**PLANNING & COMMUNITY DEVELOPMENT
DEPARTMENT**

February 12, 2020

RE: Templeton Gap Townhomes
File: CPC PUZ 20-00012, CPC PUP 20-00013, CPC PUD 20-00014, AR FP 20-00054

DEVELOPMENT PLAN  
SITE PLAN

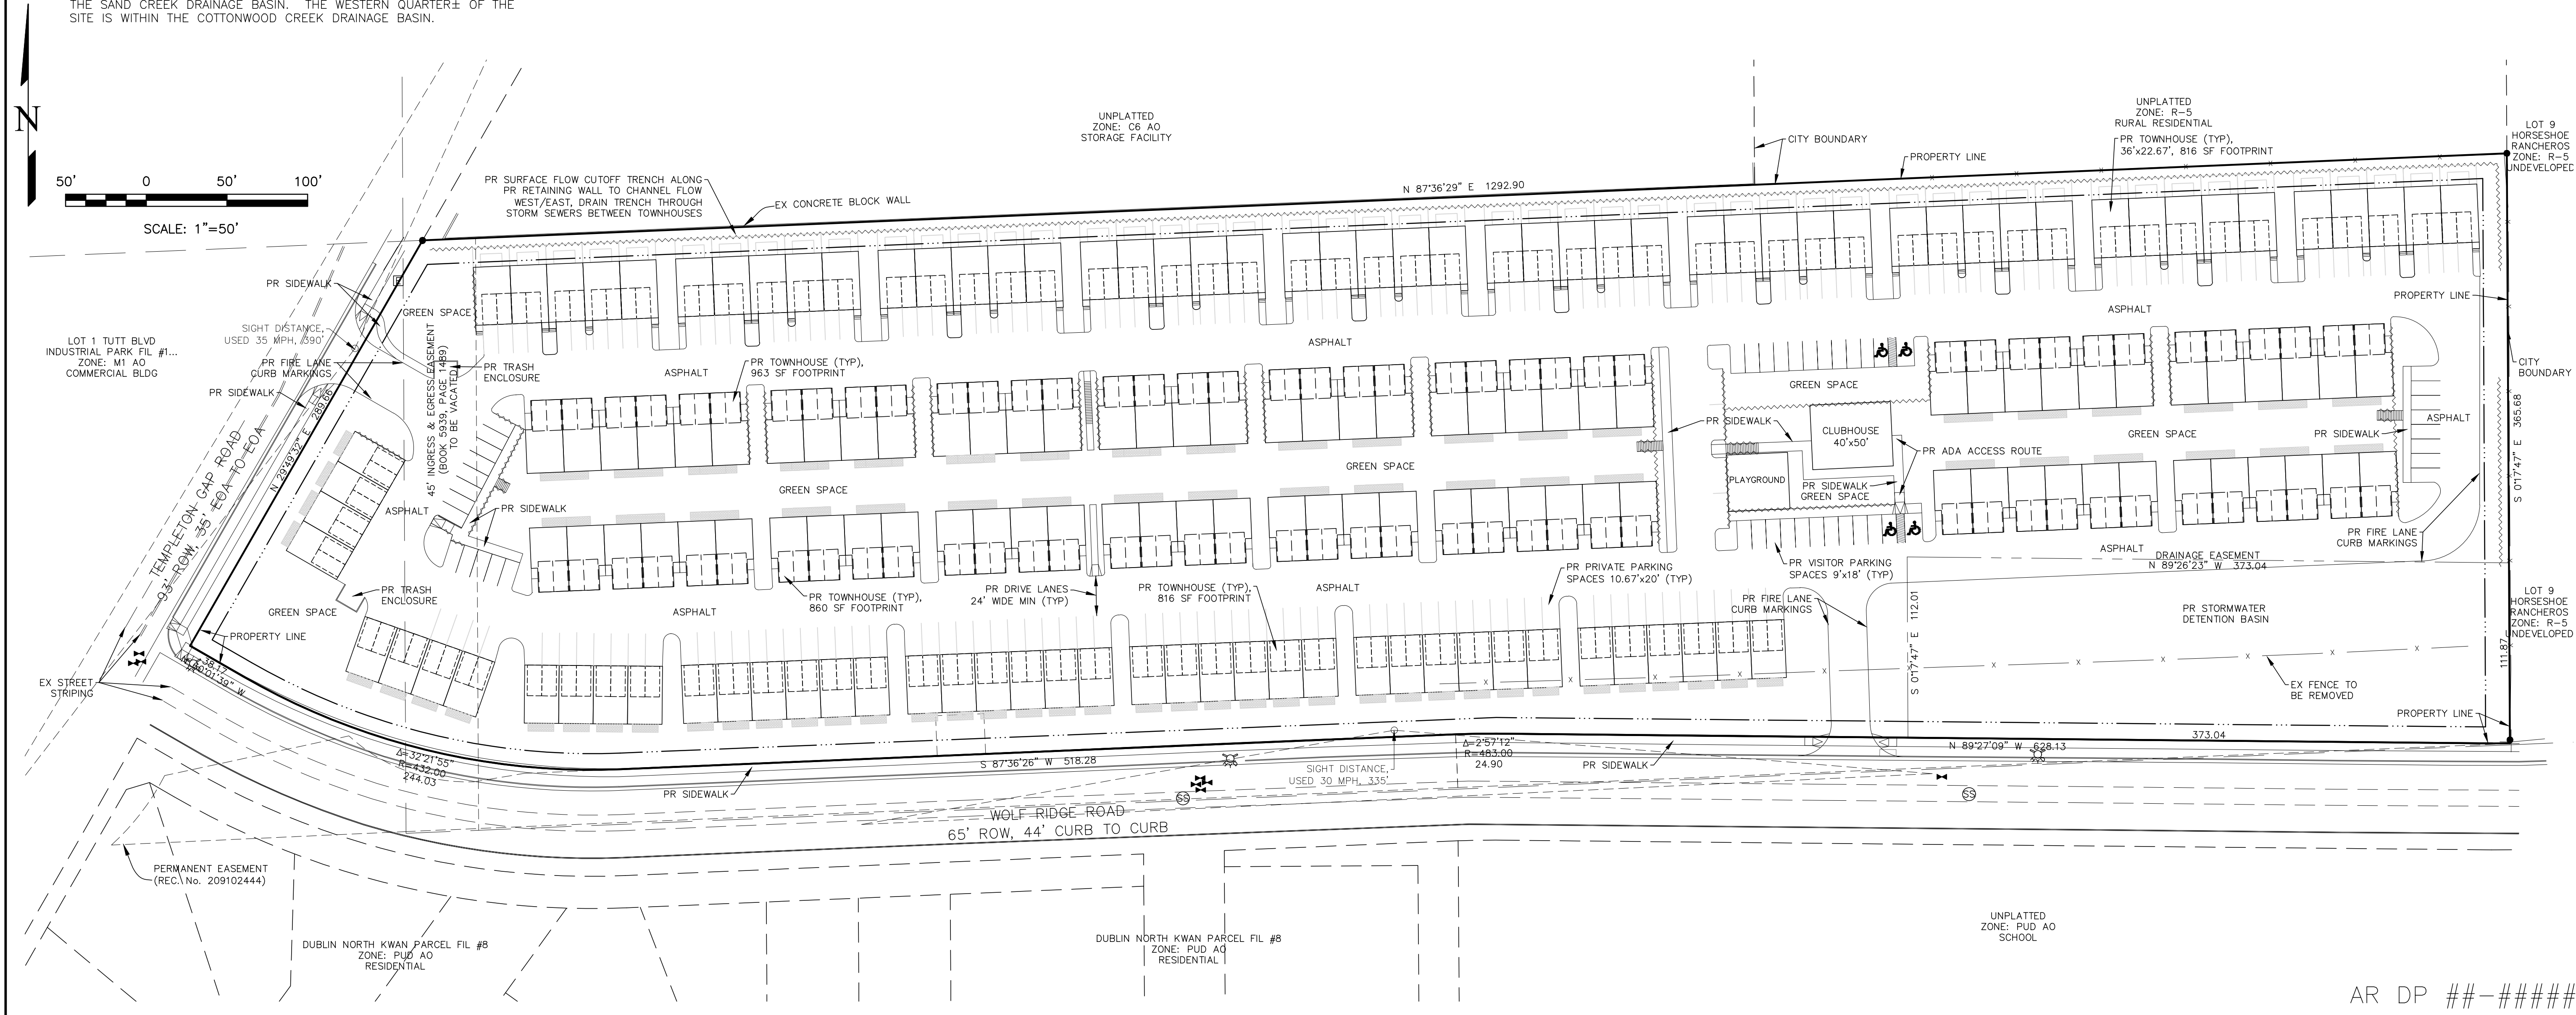
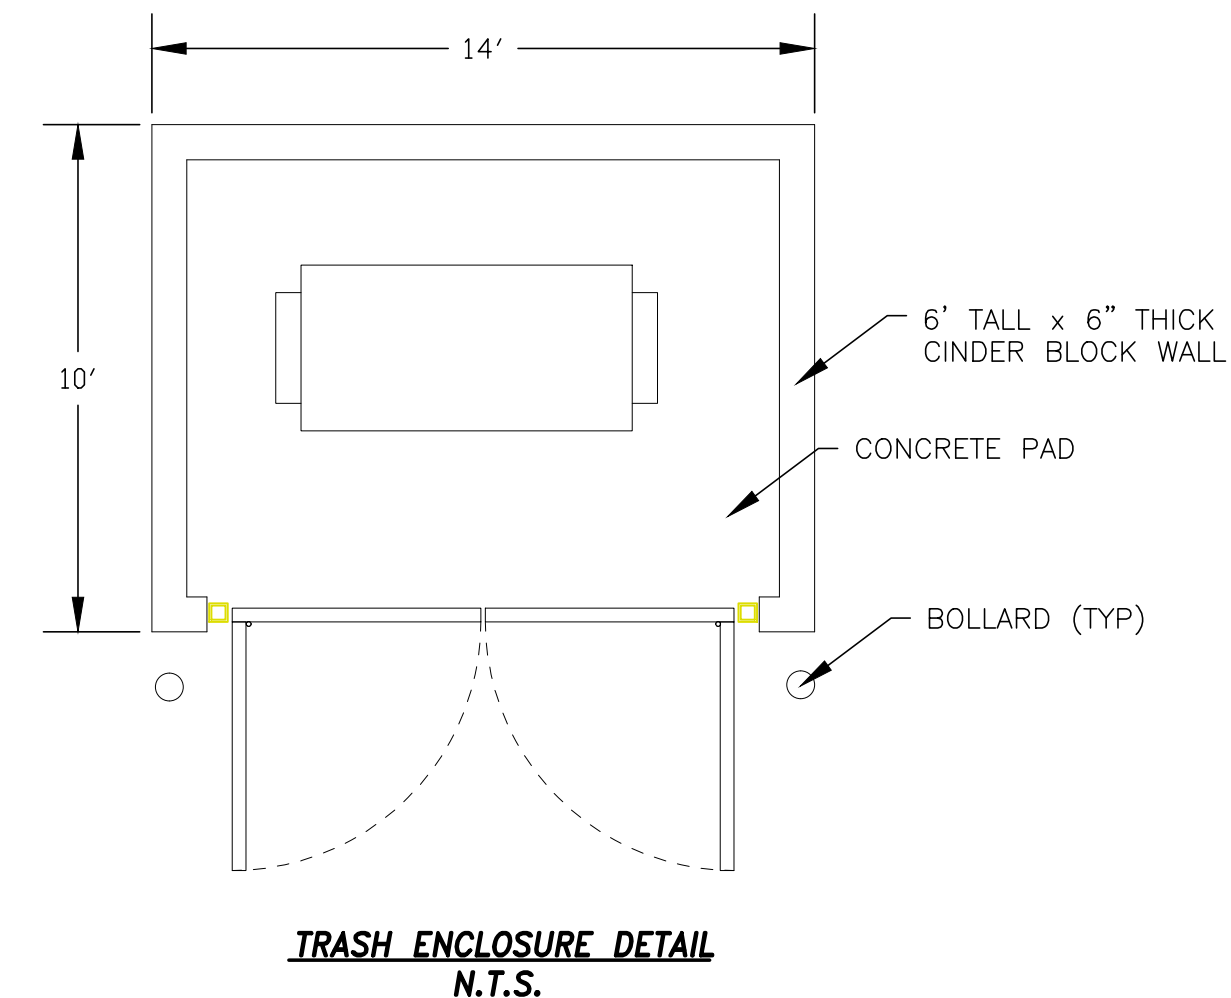
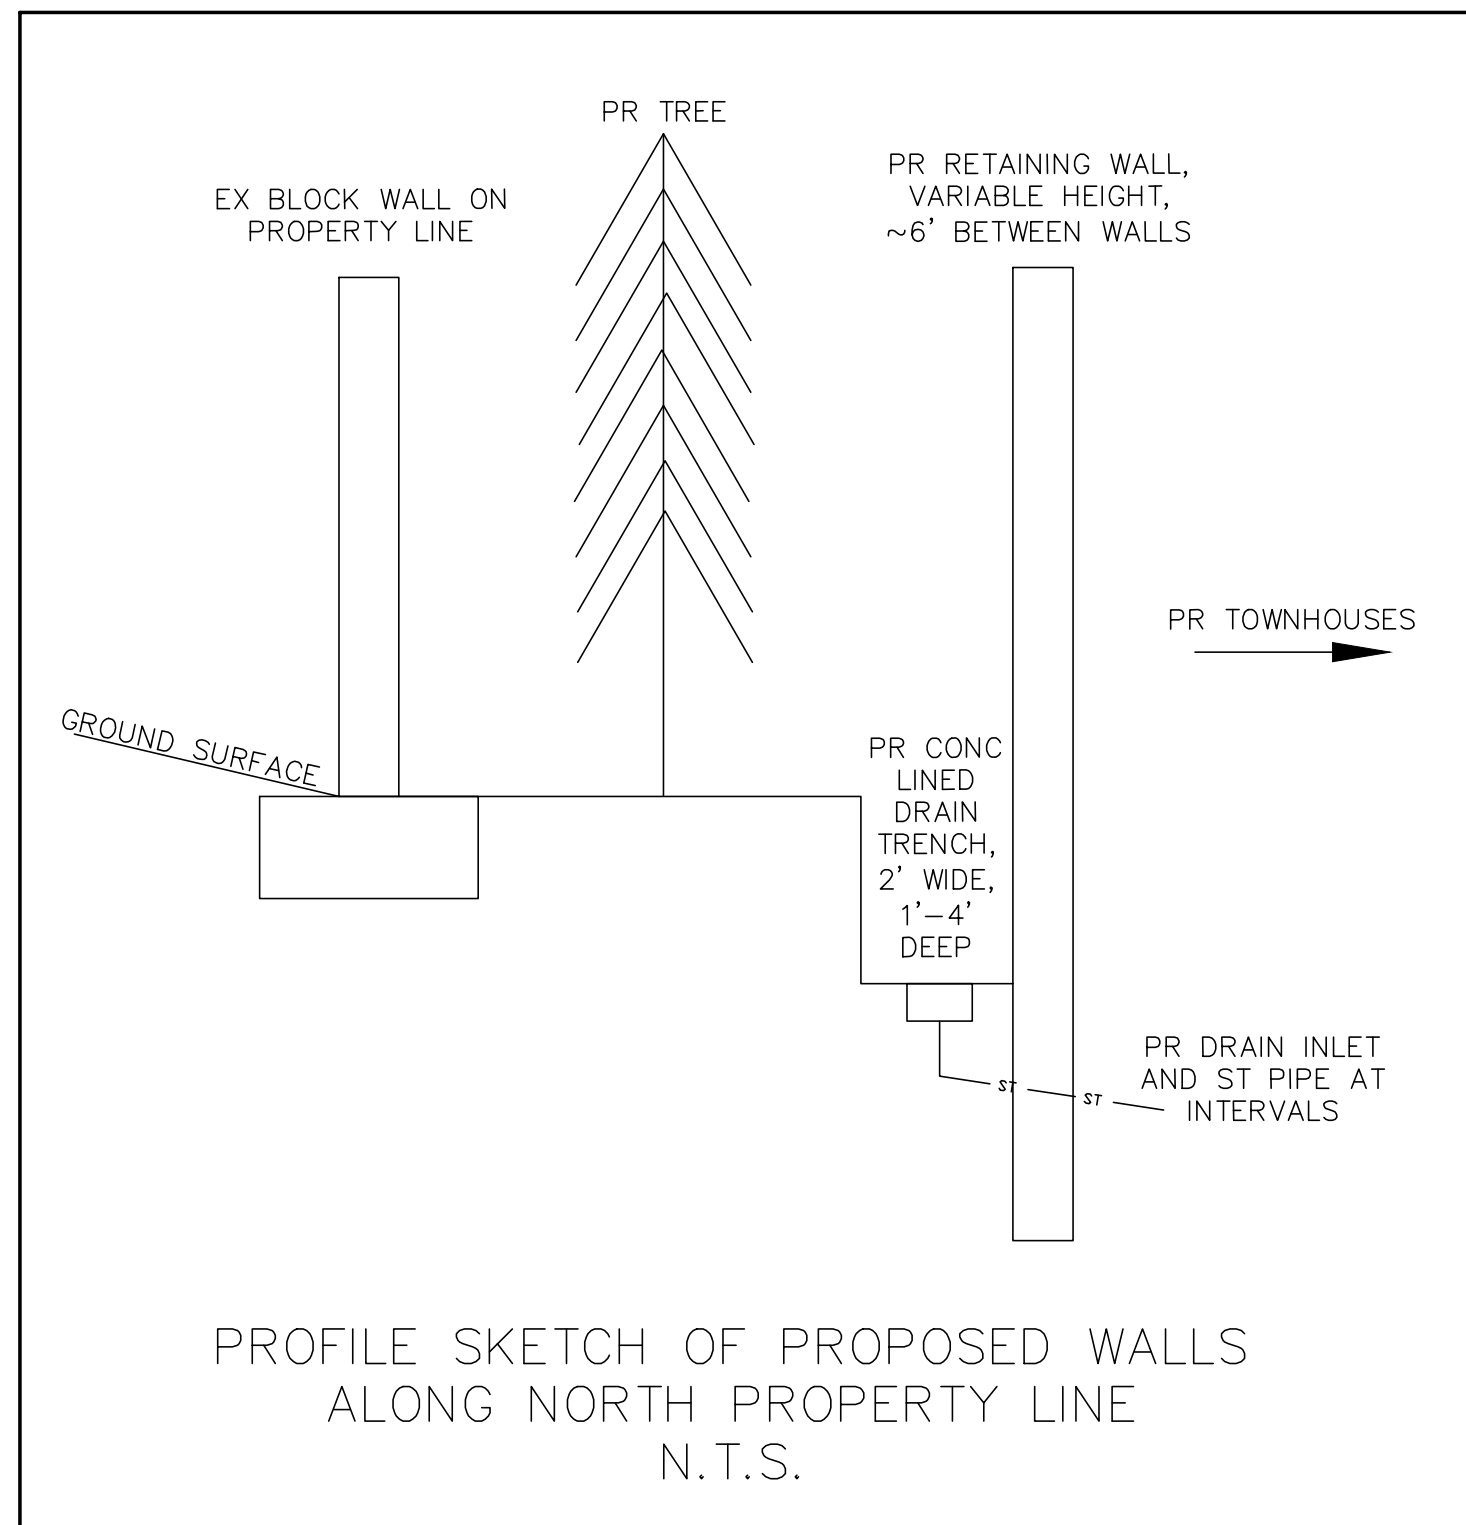
1- Please show and callout "on sheet 1 of the Development Plan" the speed line of sight with the adequate sight distance length (footage) for the proposed access along Wolf Ridge Road.

2- Please confirm "on sheet 1" that both proposed access points width are between 24-36 feet.

4. Indicate building and landscape setbacks both on the plan and in the project notes; there's a setback line indicated, but it is not labeled as to what type.

5. Identify streets as public or private.
6. Correct the sight visibility lines on the south side of the property; I think what's shown corresponded to an earlier layout for the ingress/egress there.

**TEMPLETON GAP TOWNHOMES**  
COLORADO SPRINGS, CO  
**PRELIMINARY GRADING PLAN**  
DECEMBER 2019

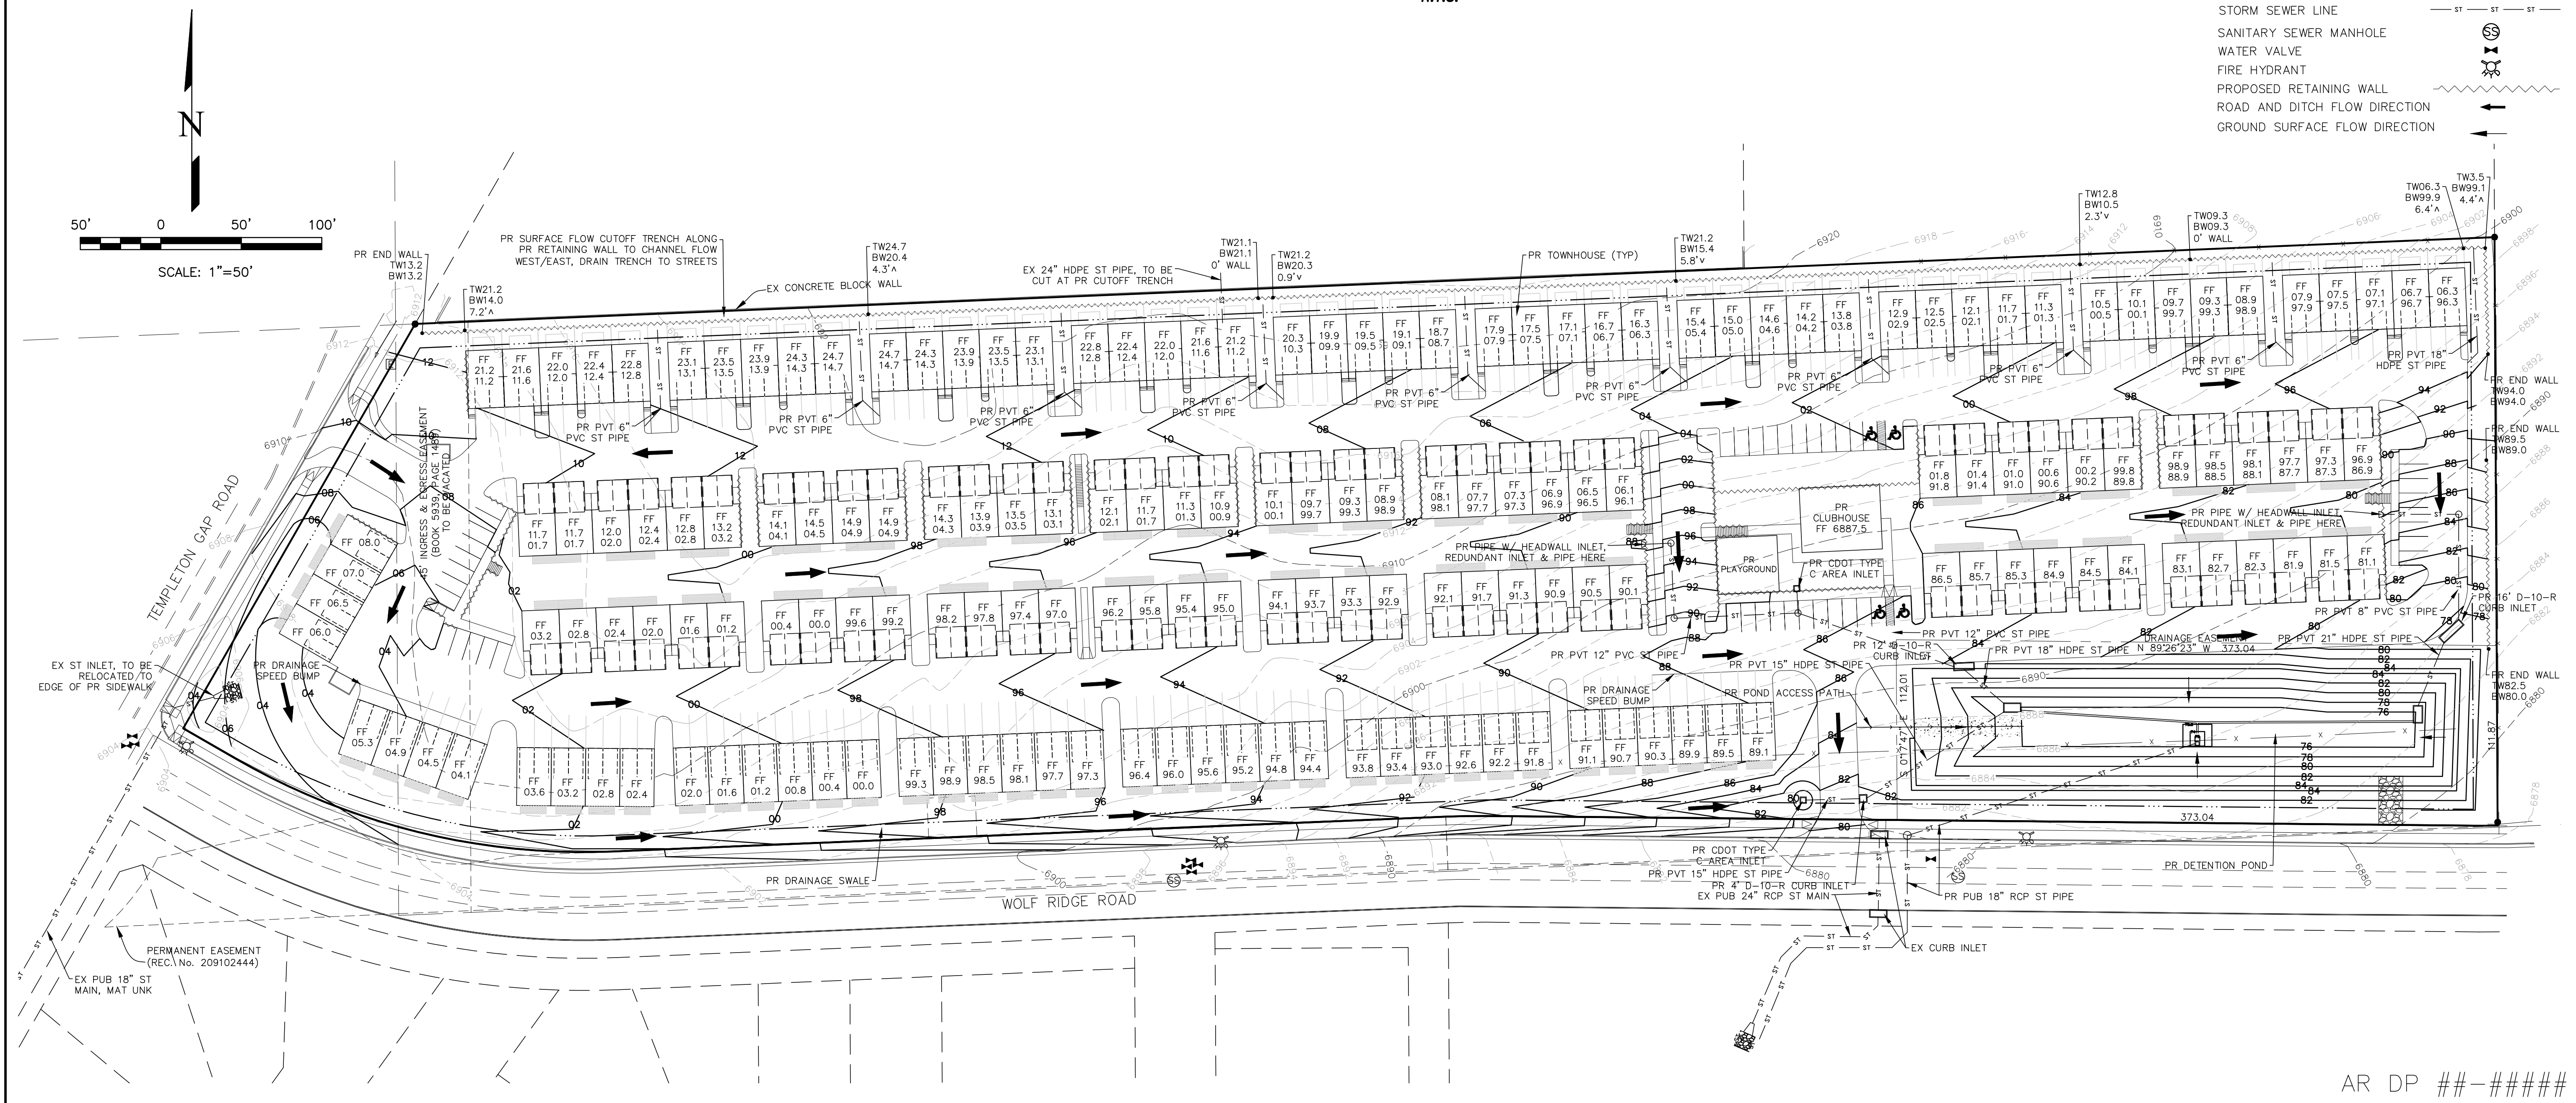
8. Update the retaining wall detail on the preliminary grading plan (sheet 2) by showing the proposed grade on the townhome side.

10. The proposed outfall from the water quality facility is daylighting onto School District 49 private property. Assure this is acceptable to the school district, on sheet 2 clearly label the ownership of the property, show and callout the drainage easements. School District 49 will have to give written approval to allow the installation on their property.
